Application for a non-material amendment following a grant of planning permission.
Town and Country Planning Act 1990

320130686P

PROPOSED ERECTION OF A NEW SPORTS HALL AND RE-ORIENTATION OF EXISTING TENNIS COURTS.

3/2012/0277

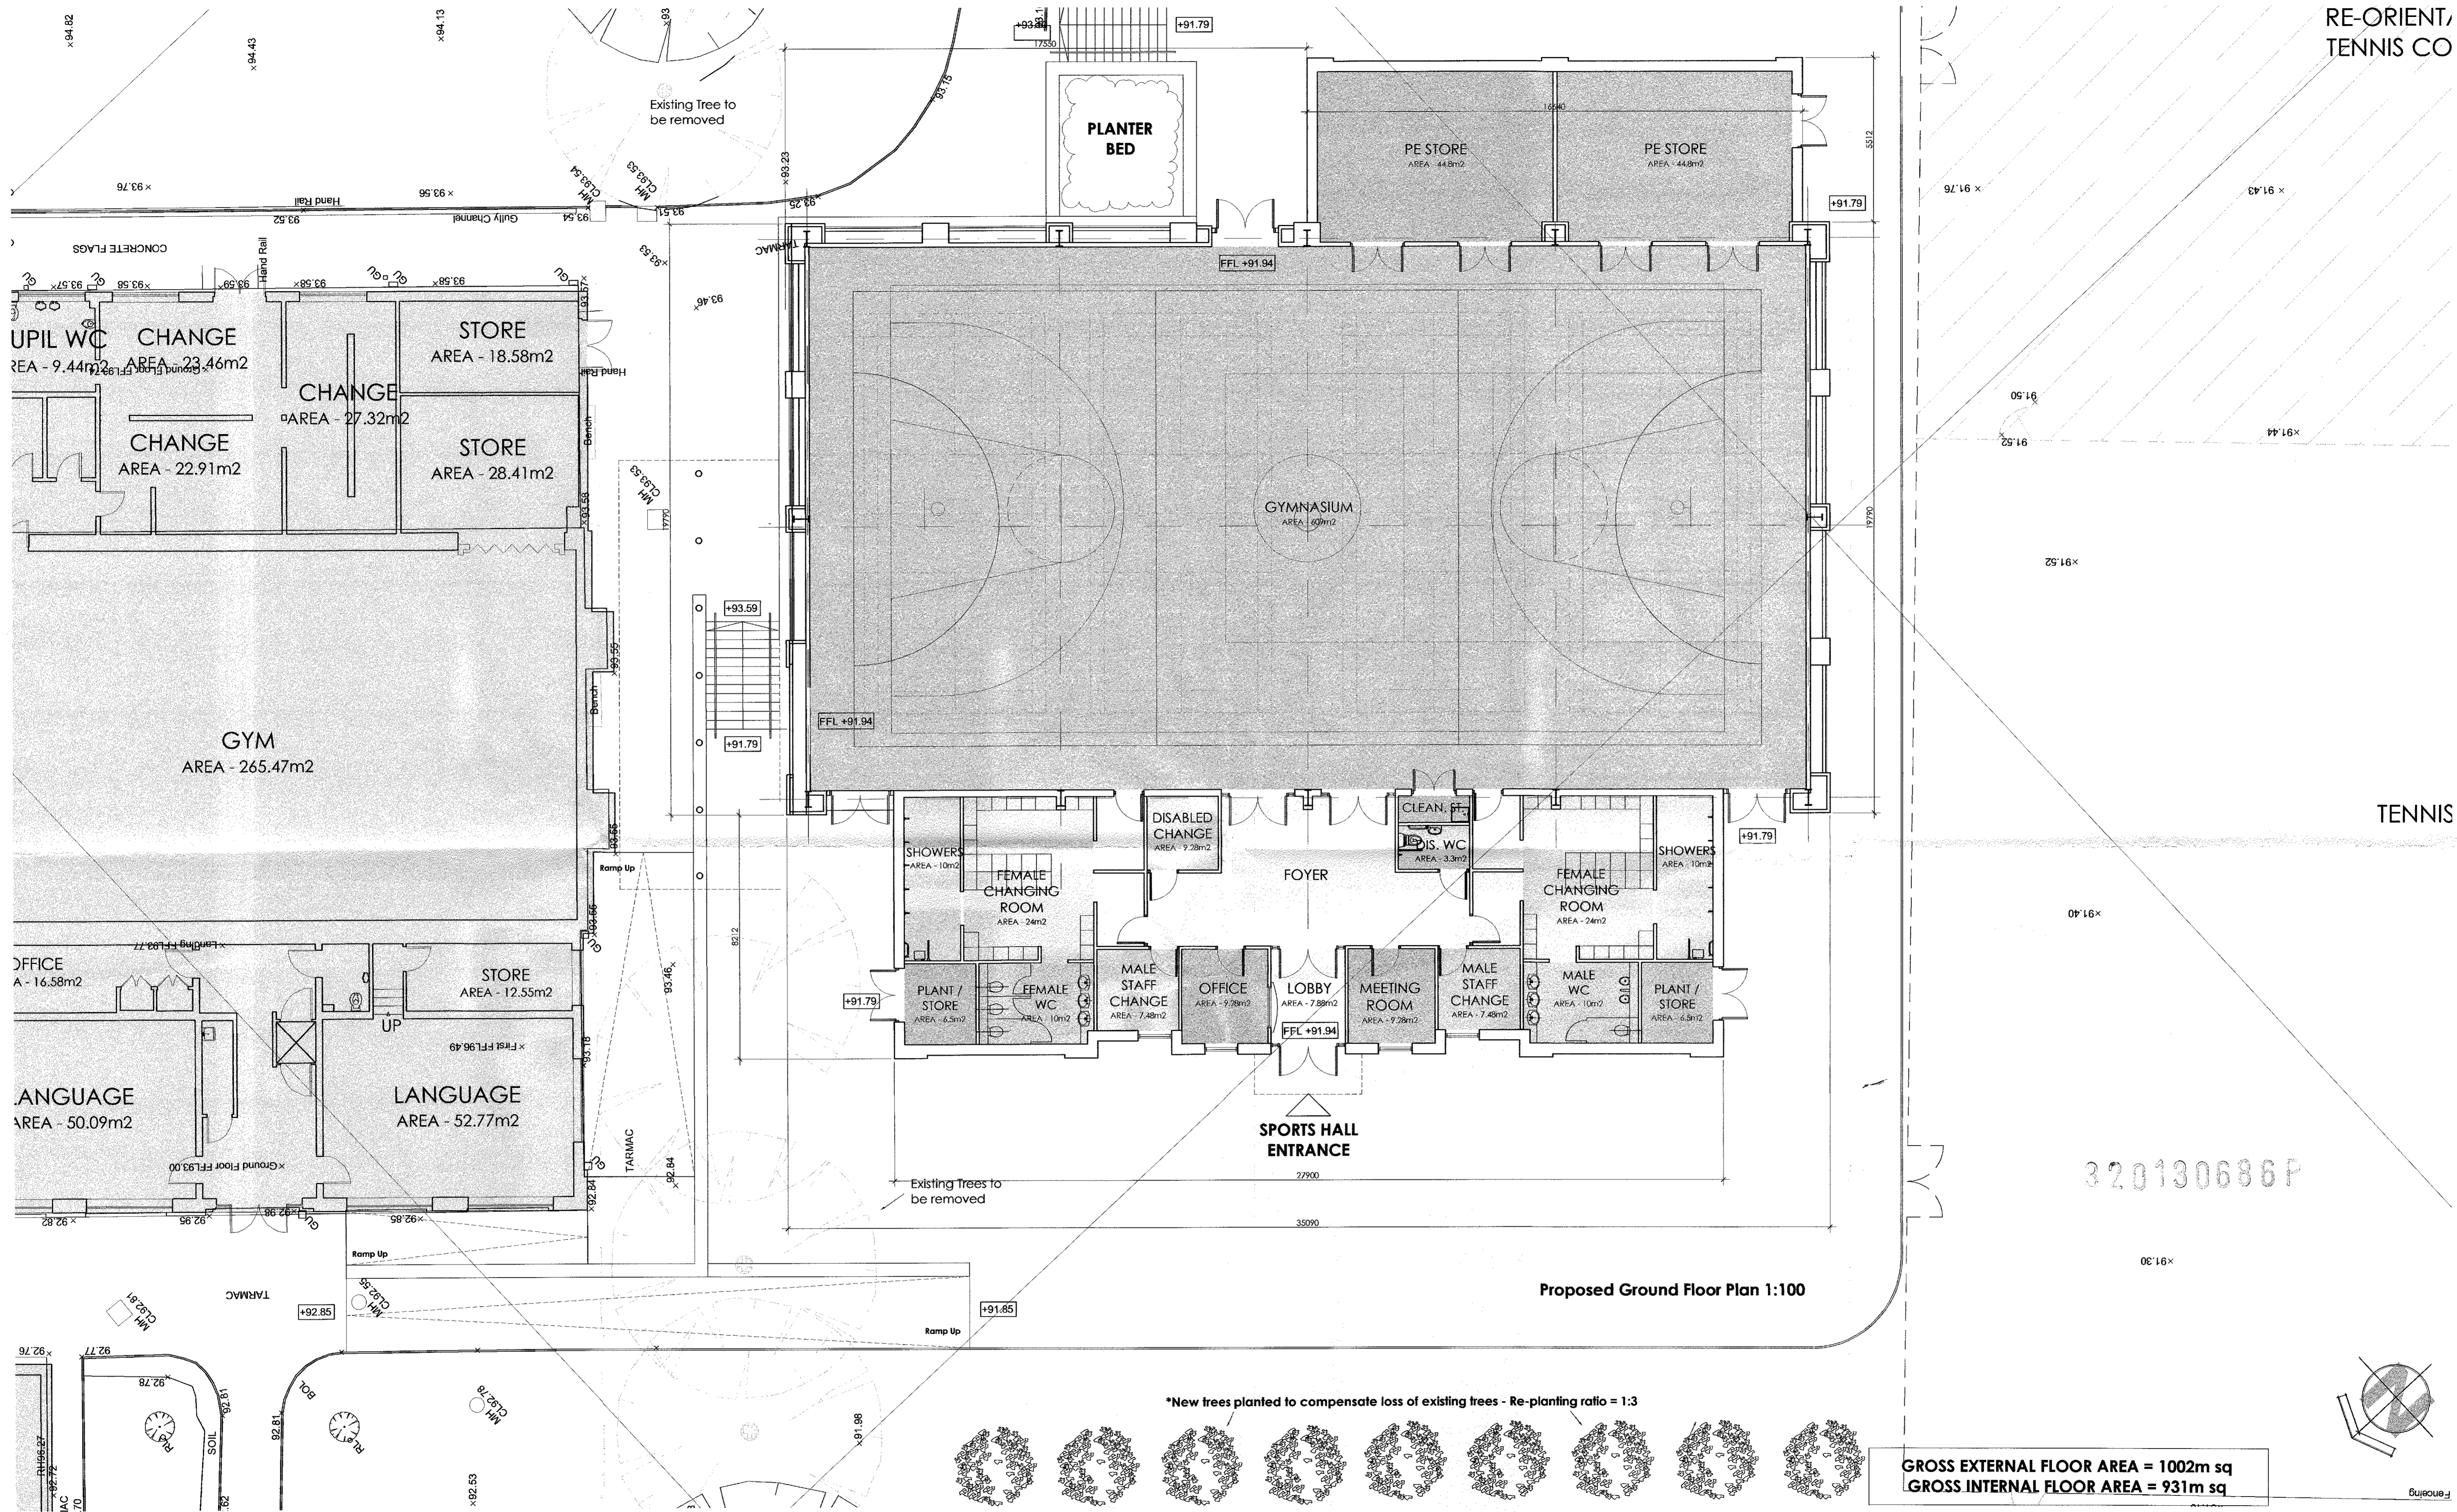
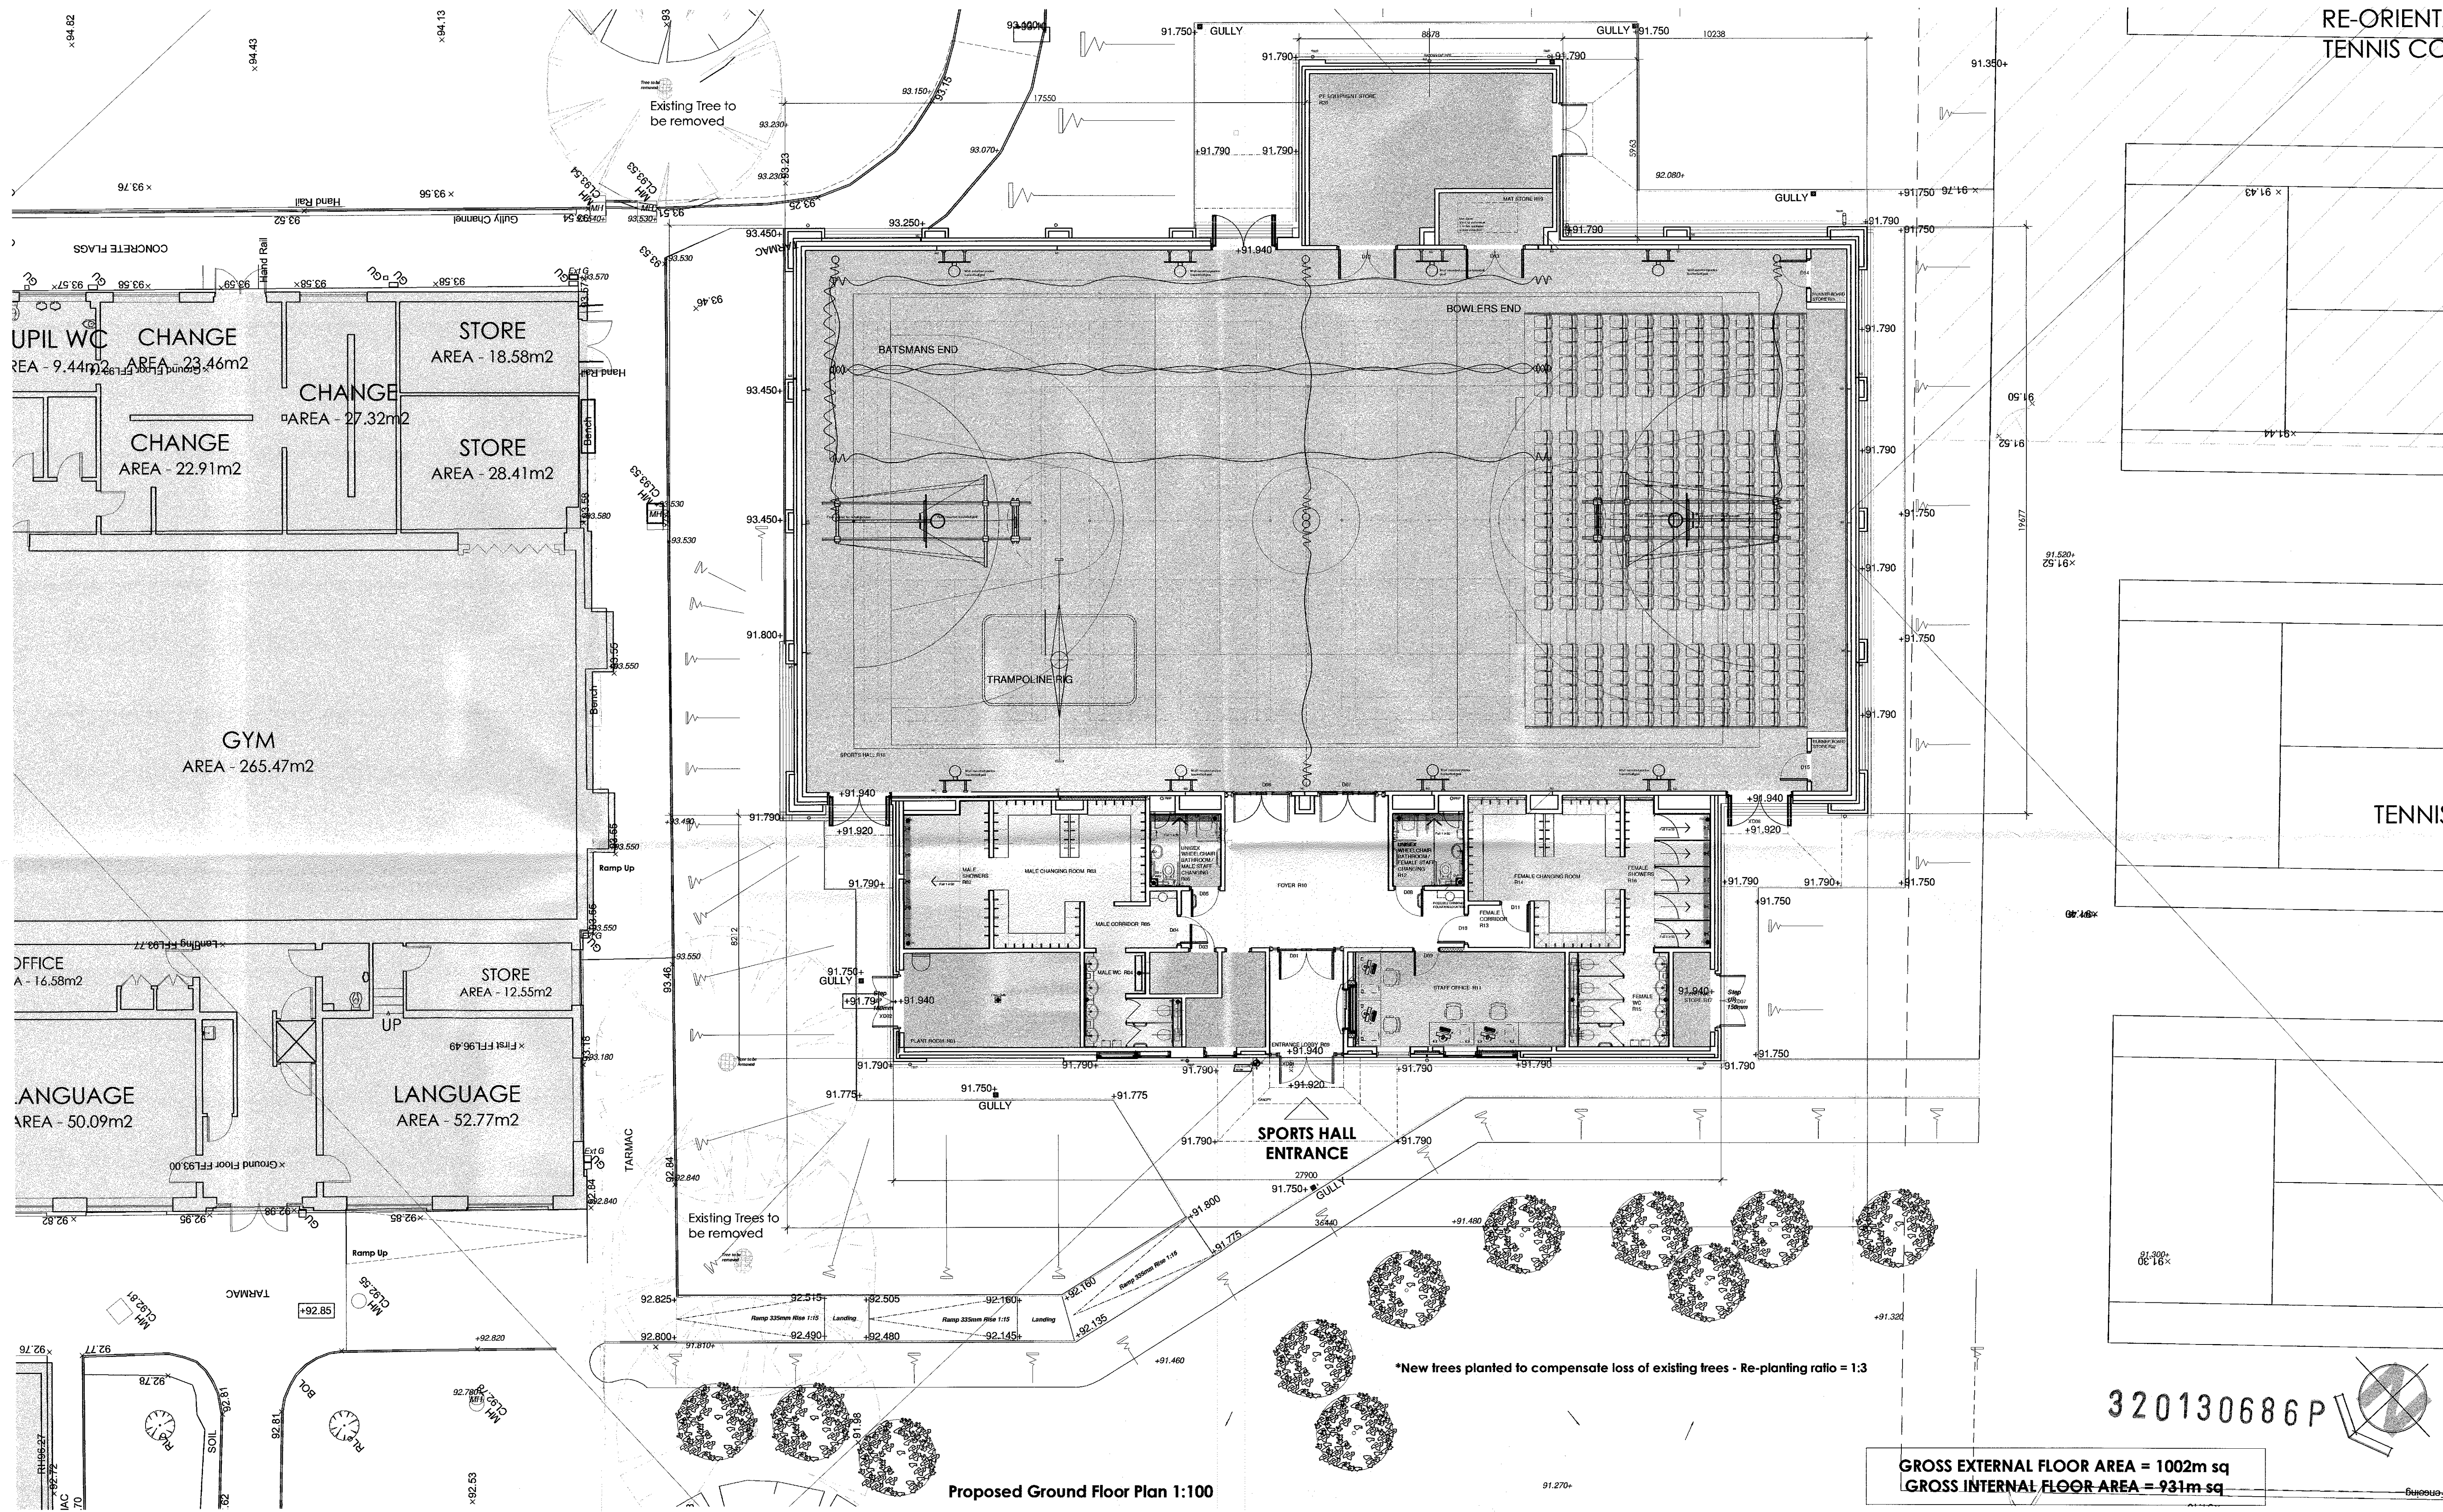
1. THE MAIN SPORTS HALL ZONE IS TO ENLARGE BY STRETCHING THE PLAN BY 1350MM TO ALLOW THE INCORPORATION OF RETRACTABLE SEATING. (ADDITIONAL _____MSQ).
2. THE SINGLE STOREY SPORTS HALL TO THE SOUTH EAST ELEVATION IS TO BE REDUCED IN SIZE (REDUCTION _____MSQ).
3. THE LOW LEVEL ALUMINIUM RAINSCREEN CLADDING PANELS TO THE SOUTH EAST AND NORTH EAST ELEVATION ARE TO BE OMITTED.
4. THE EXTERNAL WORKS PROPOSALS HAVE BEEN RATIONALISED.

THE PROPOSED ALTERATIONS TO THE APPROVED SCHEME HAVE ARISEN FOLLOWING THE CLIENT REQUEST TO INTRODUCE RETRACTABLE SEATING WITHIN THE SPORTS HALL AREA. IN ORDER TO MAINTAIN MINIMUM SITE STANDARDS WITHIN THE HALL THIS HAS NECESSITATED THE ENLARGING OF THE HALL BY STRETCHING THE HALL BY 1350MM ON THE SOUTH WEST ELEVATION. AT THE SAME TIME THE SINGLE STOREY HALL STORE HAS BEEN REDUCED IN SIZE TO CREATE AN OVERALL NET REDUCTION IN FLOOR AREA FROM THE APPROVED SCHEME.
